**Consultation Response from KC,
Highways Development Management**

2023/91896 Poplar House, 35, Old Lane, Birkenshaw, BD11 2LA

Change use of dwelling to day nursery

Date Responded: 06/09/2023.

Plan Produced for: Steven Leonard
Date Produced: 24 Jun 2023
Plan Reference Number: TQRQM23175140746453
Scale: 1:500 @ A4

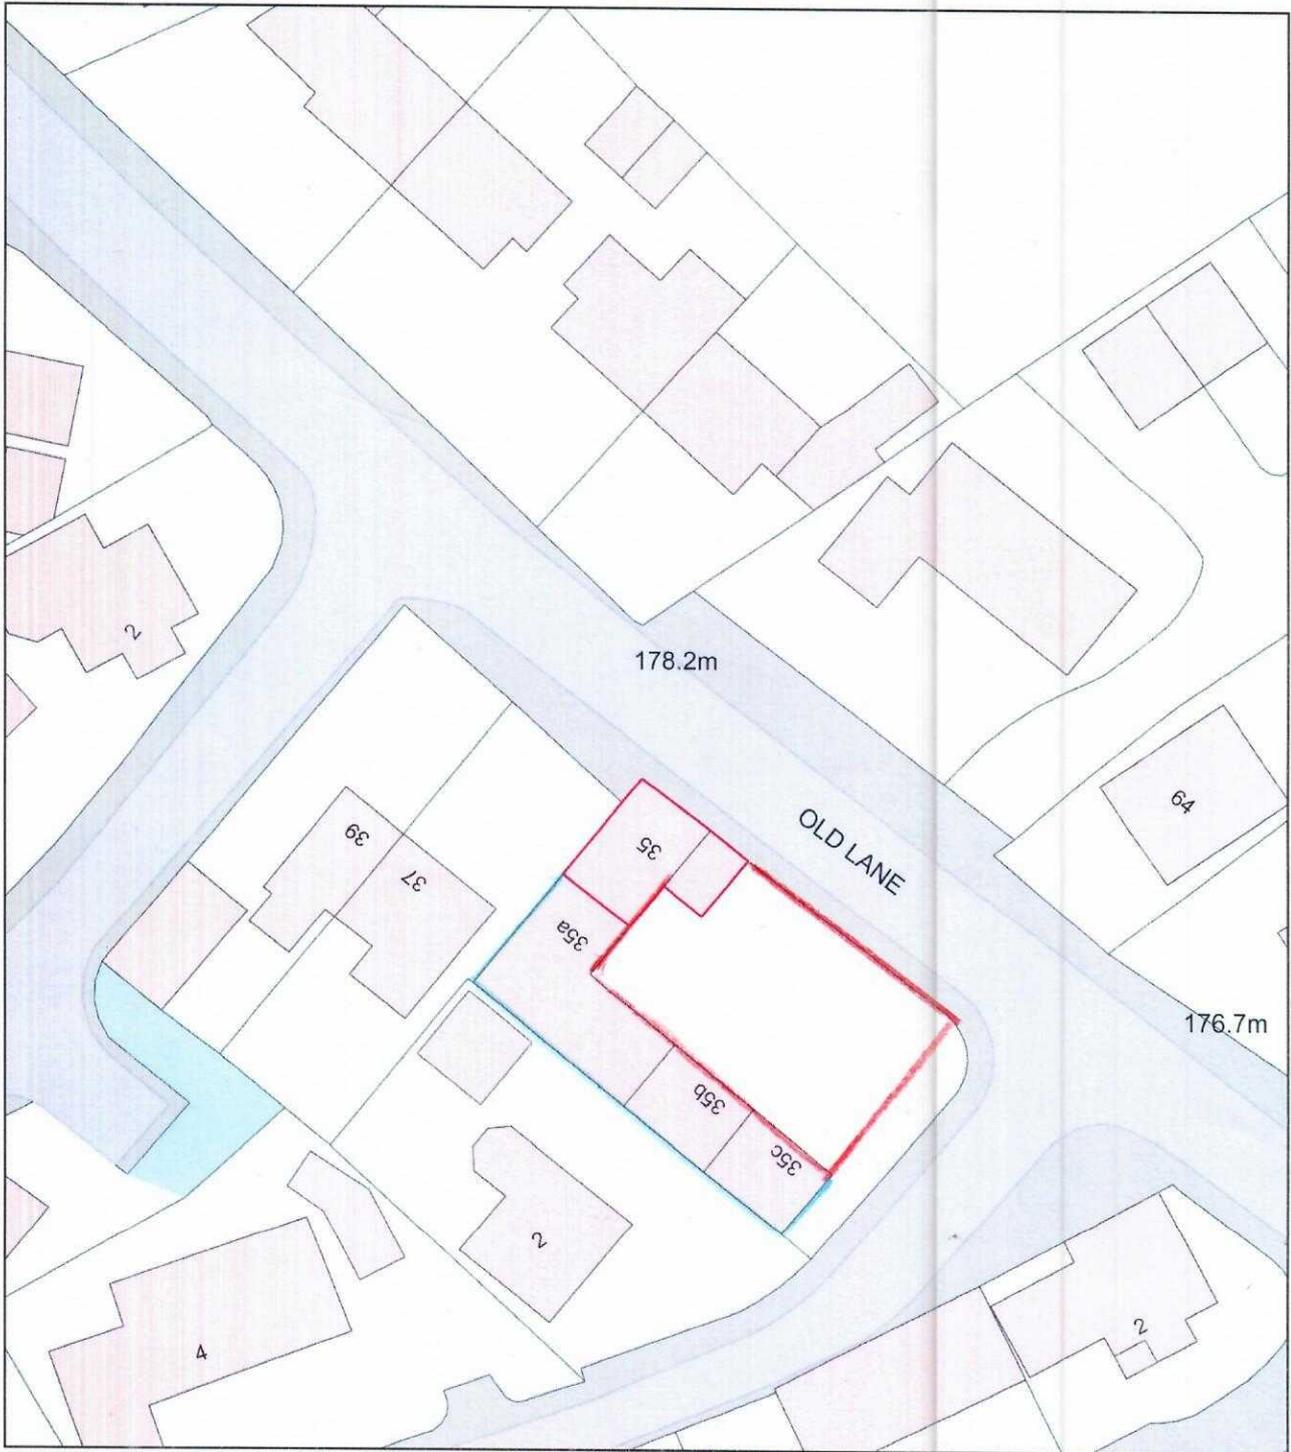
Clarification of the existing and proposed use of the car parking area is required.

The Applicant states that 8 car parking spaces are available on the site. However, these appear to be allocated to the existing four dwellings at 2 car parking spaces per dwelling.

I would consider, therefore, that only 2 car parking spaces are available for the proposed nursery, which would be reduced to potentially none if a secure outside play area is required.

Clarification of the existing and proposed car parking arrangements are required. Which would also include any secure outside play area if required.

The Applicant states that commercial waste bins will be used. However, no location has been identified for the location of the bin store.

Details of waste storage and collection should be provided, with the location of a waste storage area being clearly marked on a drawing in such a location that is easily accessible to the collection team and where it will not obstruct the parking, access, or the adopted highway for road safety reasons.

There are high walls on either side of the vehicle access, and these would need to be lowered to provide a 2.0m x 2.0m pedestrian sight line where the drive meets the back of the footway.

There should be no physical obstructions or planting within these areas, that have the potential to grow above 0.6m high.
